CITY OF ALBUQUERQUE

**Re: Los Duranes Community Center, 2920 Leopoldo Road NW,
Traffic Circulation Layout
Engineer's Stamp dated 05-14-12 (H12-D001)**

**GRADING AND
DRAINAGE PLAN
CG-101**

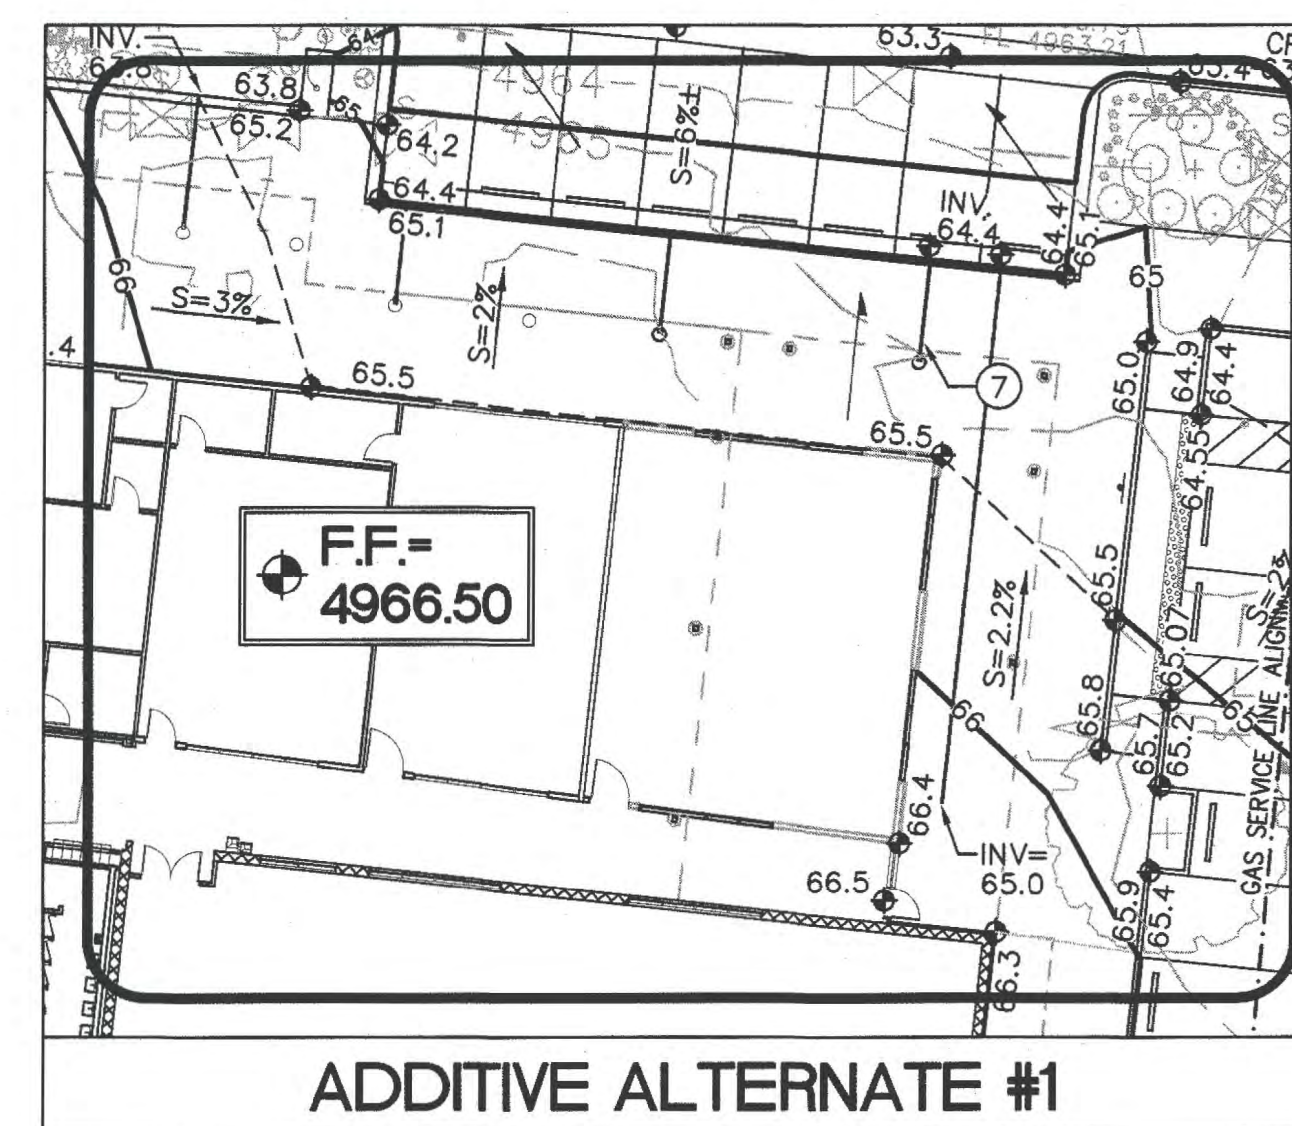
1. Please include a copy of sheet CP-102 for reference.
2. Provide an overall site plan, defining the location of the proposed improvements within the site.
3. Leopoldo Road is defined as a "private street." Clearly show the access easement for Leopoldo Road; define beneficiaries and provide recording information.
4. A five-foot keyway is required for deadend parking aisles.
5. What is the existing status of Leopoldo Road? Is it a one-way roadway where it ties into the Los Duranes Ditch? Is it limited access?
6. Define the 6-foot wide, ADA accessible, pedestrian pathway from the roadway to the building.
